FAO: Planning Department,
Welwyn Hatfield Borough Council

Ref: 6/2023/0397/HOUSE
Date: 04/06/2023

HISTORIC BUILDINGS AND CONSERVATION ADVICE

RE: *The Cottage, Oshwal Centre, Coopers Lane Road, Northaw, Potters Bar, EN6 4DG*

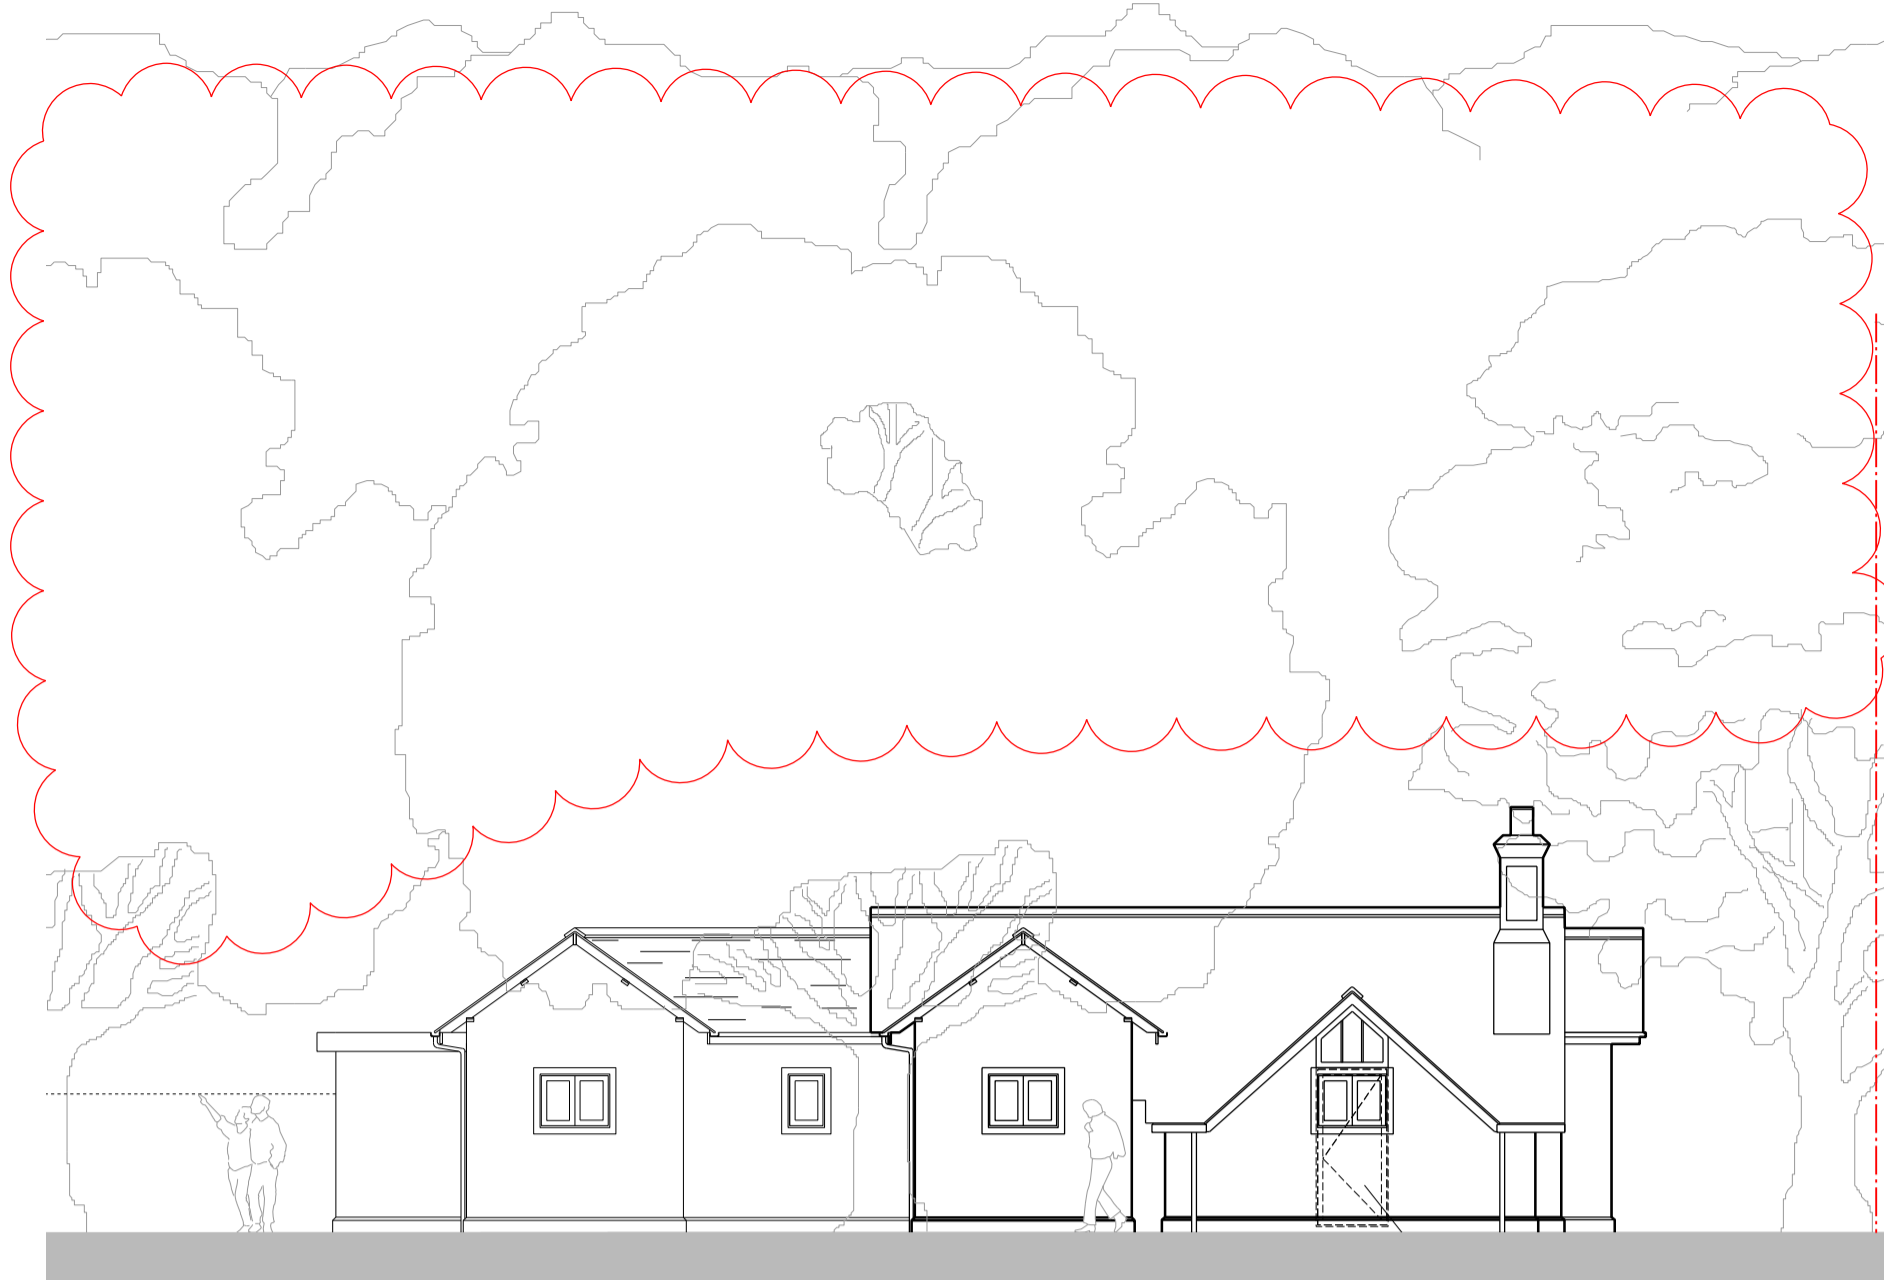
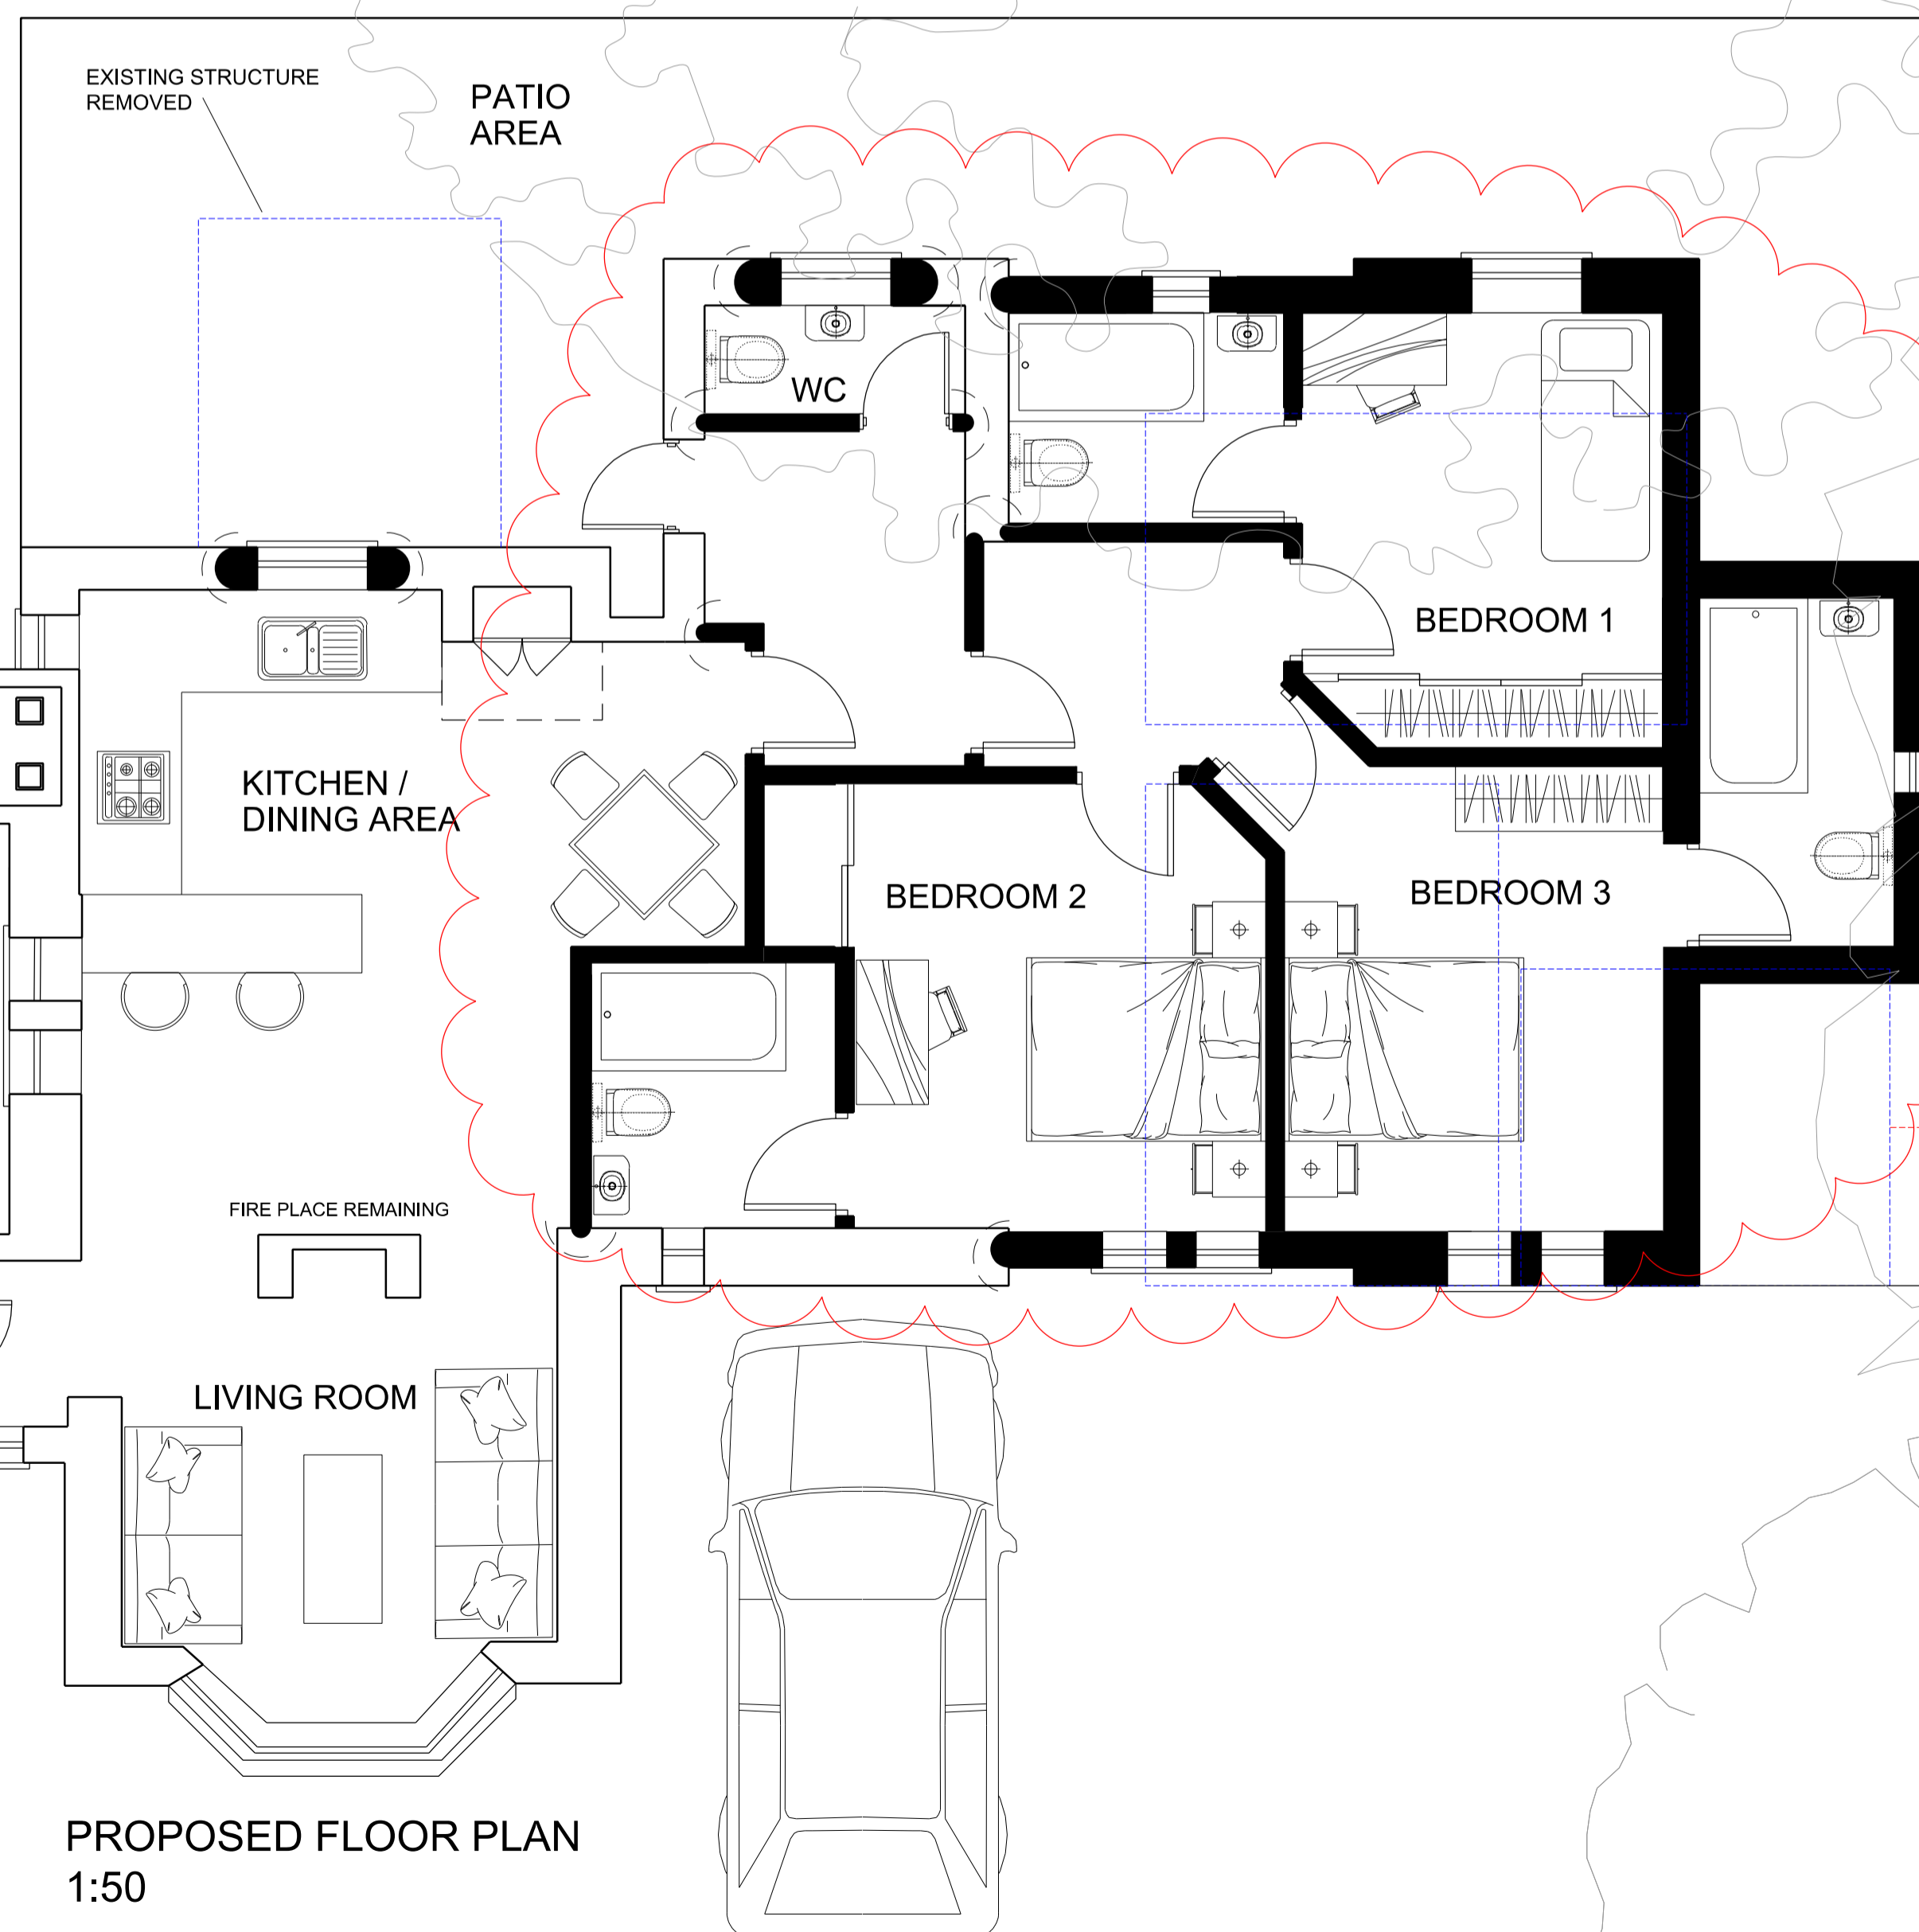
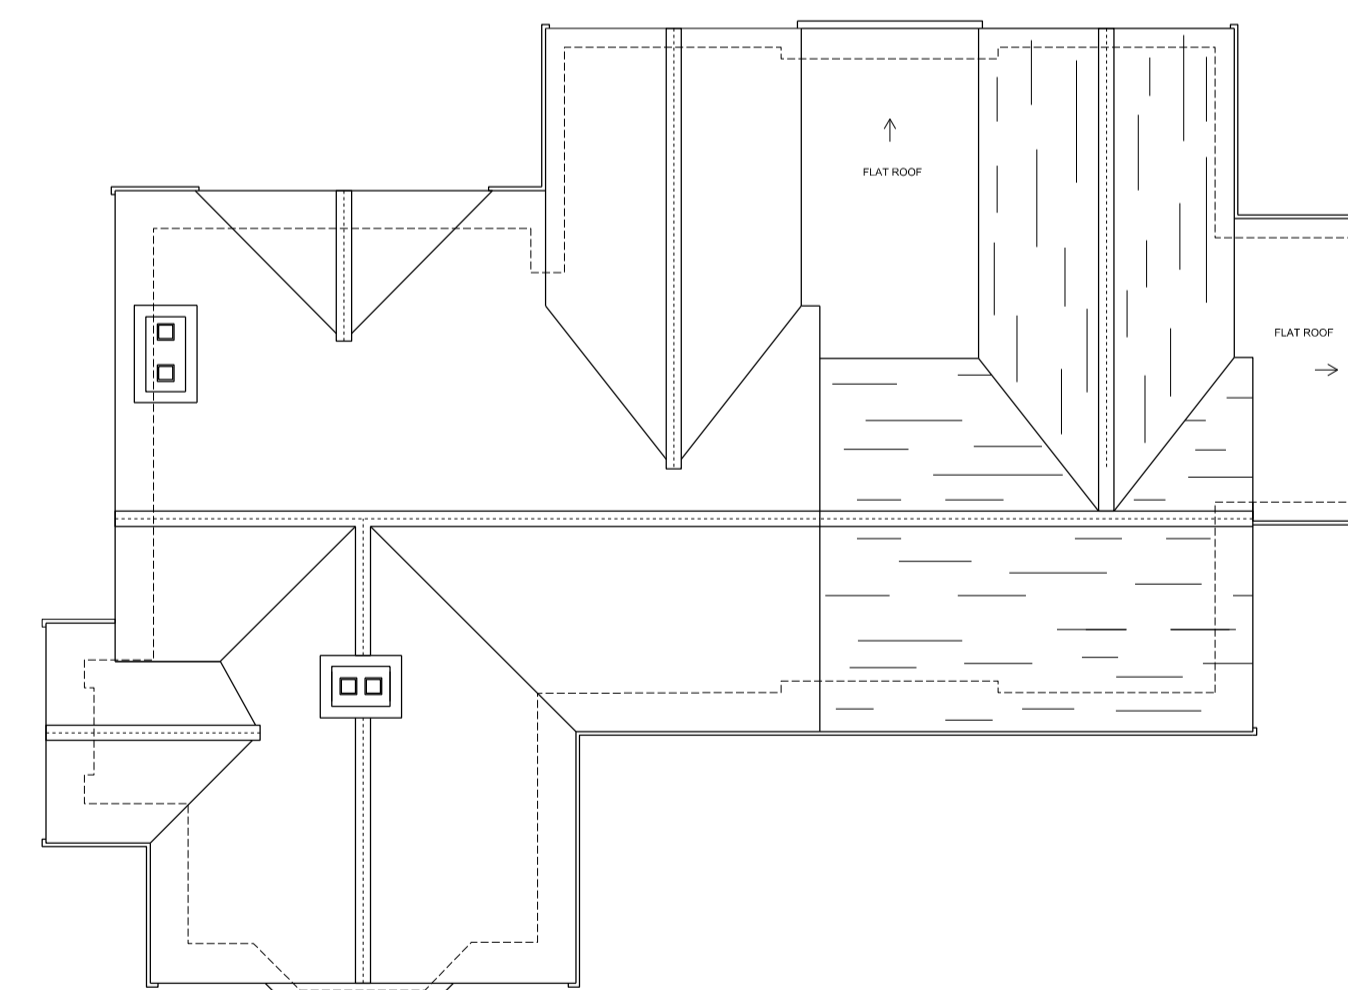
The proposals are not sympathetic to the historic form and proportions of the building and are not based on an understanding of its significance. The scale of the proposed extensions undermines the scale of the lodge building and its historic form. Elongating the south east elevation creates an uncharacteristic long elevation fronting the drive. The proposed flat roofed elements (between existing and new gabled projections on the north west elevation, and projecting from the north east elevation) are incongruous additions to the building which do not relate to its traditional form.

Substantial internal alterations are proposed with no assessment of the potential loss of historic fabric and planform which would result in harm to the building's significance by impacting its architectural interest.
